**MAJOR PROJECT NO. MP 08-0080
SUBDIVISION LOT 112 DP 1073781
LYONS ROAD, NORTH BONVILLE
RESPONSES TO COMMENTS BY DEPARTMENT OF PLANNING AND
INFRASTRUCTURE AND SUBMISSIONS FROM AGENCIES**

**Re: Preferred Project Report MP08_0080: Residential Subdivision
Lyons Rd, North Bonville**

RE: Borsato's Sub-Division – Lyons Road, East Boambee

ROAD PROFILE 9 FIRE TRAIL

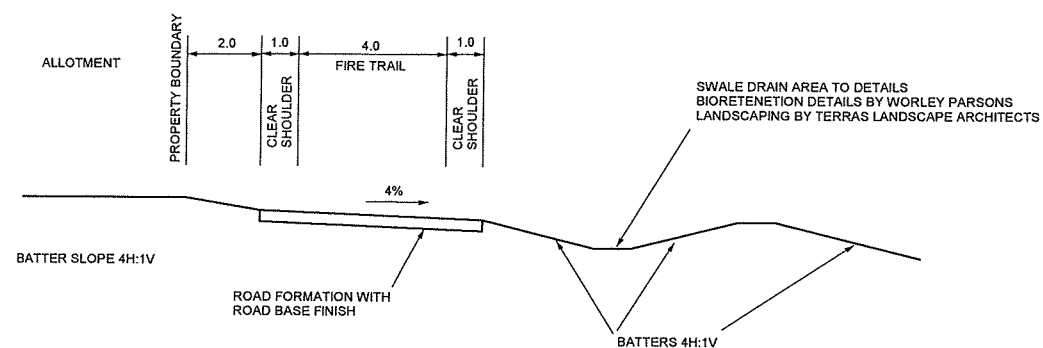
The RFS has indicated that preferred access to the NP&WS fire trails be located no further apart than 200 metres. However the RFS is prepared to assess your Agency's requirements for access on the basis of overall fire protection for the total development. Can you indicate at what locations you require vehicle access gates?

7. Agreement should be reached among relevant parties before approval on the issue of spacing of fire trail related access points that connect the fire trail system with the public road network.

Additionally, it is understood the RFS proposes that the fire trail is to be connected to the public road at frequent intervals of 200m, presumably to facilitate a connection for fire truck/vehicles. OEH/NPWS consider that such a spacing would be excessive, taking into account the nature of the vegetation in the National Park. It is recommended that agreement on this issue be reached among relevant parties before approval of this proposal.

The preferred strategy for providing emergency vehicular access to the western fire trail from the Borsato holdings would be by way of a standard padlocked farm gate. Two to three gates only would be sufficient for this purpose entering onto the national park on the drier, more elevated country either side of the existing cattle yards on your client's land.

Given the frequently swampy and impassable nature of national park land adjoining the southern boundary of the development site it is our opinion that any vehicle access gates placed in this vicinity may have little fire fighting utility and could in fact endanger fire fighters by inviting access into areas where they may become bogged and trapped.
